From: Mark Warwick <Mark.Warwick@arun.gov.uk>

Subject: RE: WA/7/19/RES - Lanes End, West Walberton Lane - Additional information request

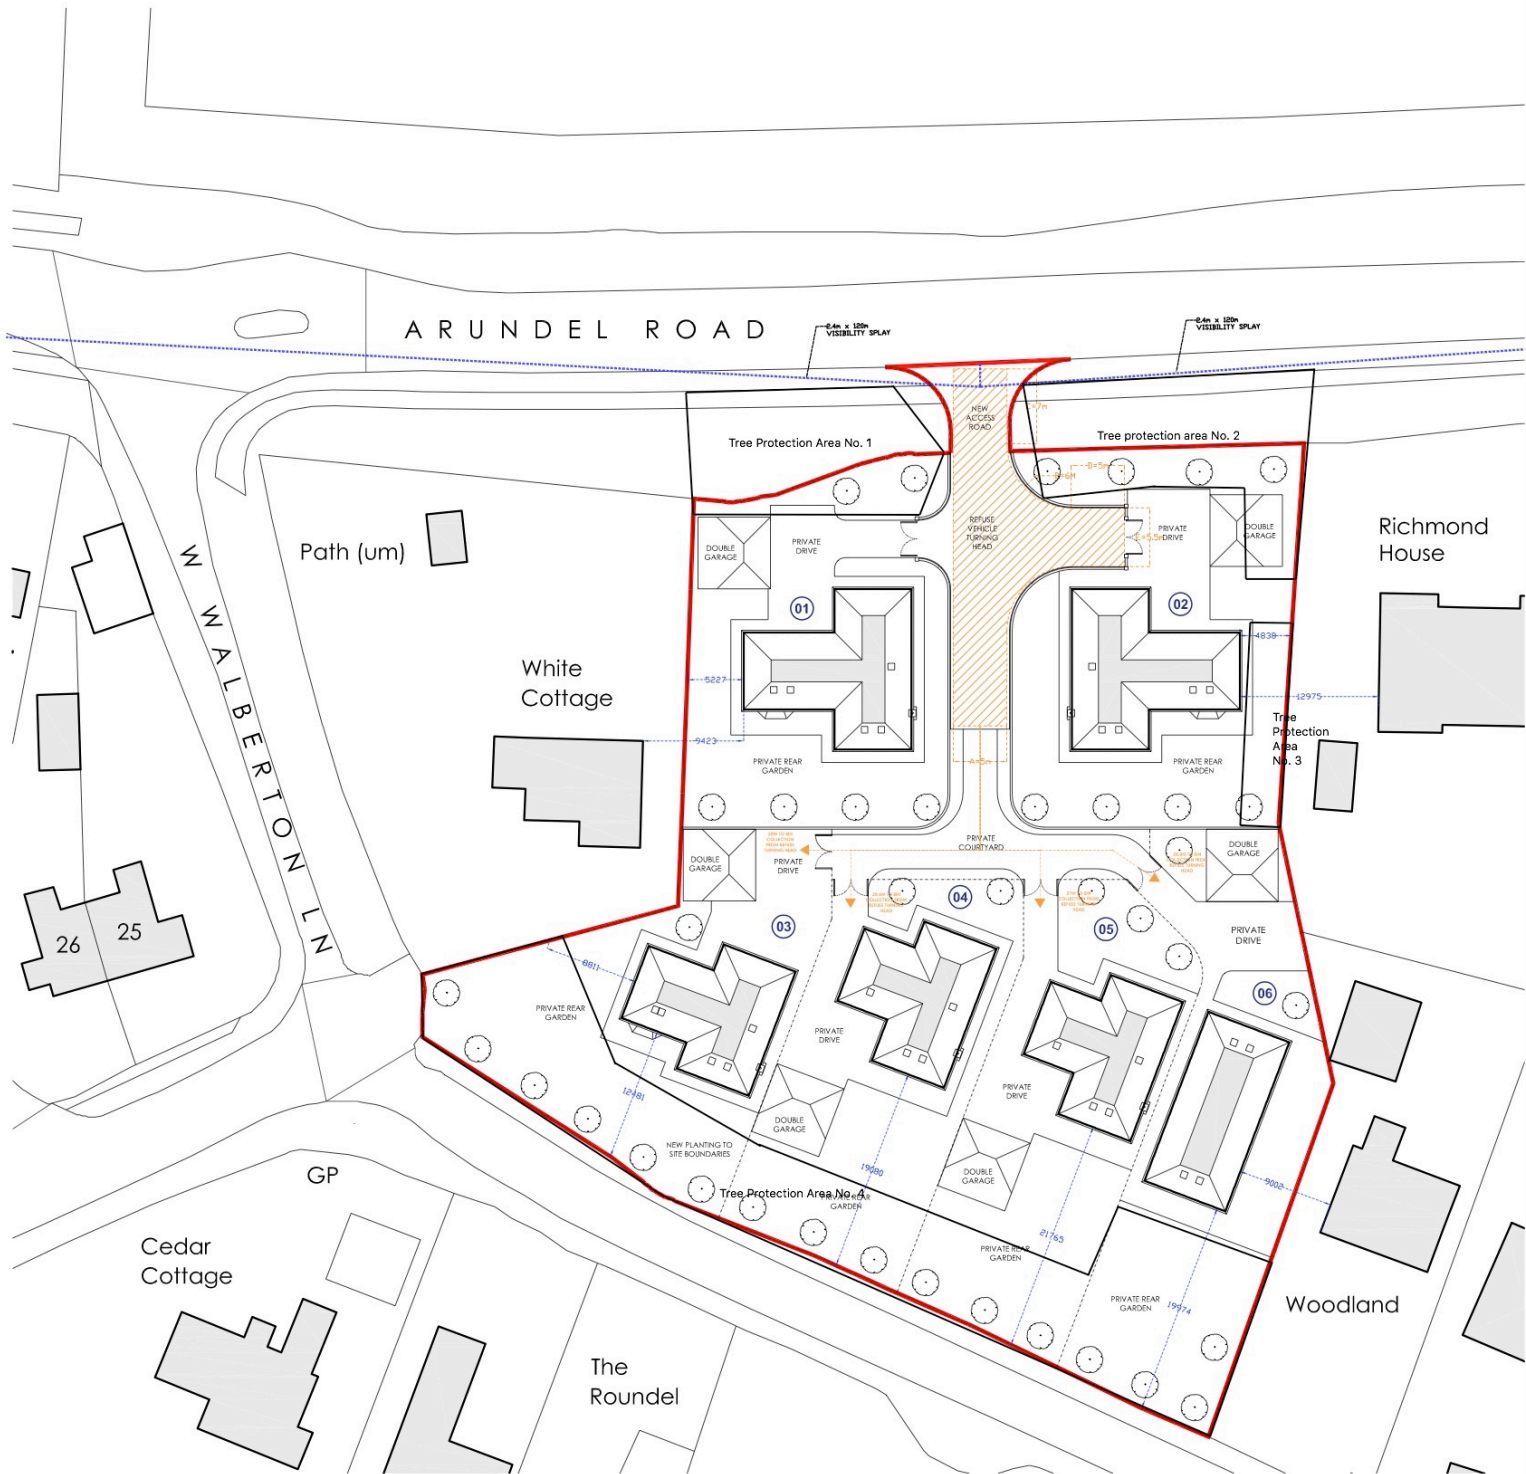
This is not an adequate Tree Protection Plan. It does not meet the requirements of the British Standard 5837:2012.

The plan is neither to scale nor based on a topographical map – so it is not possible to determine precisely where the tree protection measures are to be installed. It is only a sketched drawing (an illustration at best) – which is surprising given the typical standard of plans submitted (this was a first for me!) and not at all consistent with the high standard of report it is associated with.

Unfortunately, the applicant has not provided a Tree Protection Plan showing the precise detail of what measures are to be applied and where. This is essential before we can recommend approval, as without a specific plan there is no way we can ensure retained trees will be protected.

Please find attached drawing showing tree protection area, We have identified four areas to be fenced off for protection during the condition phase, These not only include all the trees with TPO's on but also include all the mature trees along the southern and northern boundaries and the ash trees to the eastern boundary. No work would take place within these areas and they would be fenced and signed off in accordance with the Tree survey submitted.

Work would be required in tree protection area 2 for the garage of property two which would be a pile and raft foundation and done under the requirements set out in the tree survey to prevent and damage to the root systems of the nearby trees.
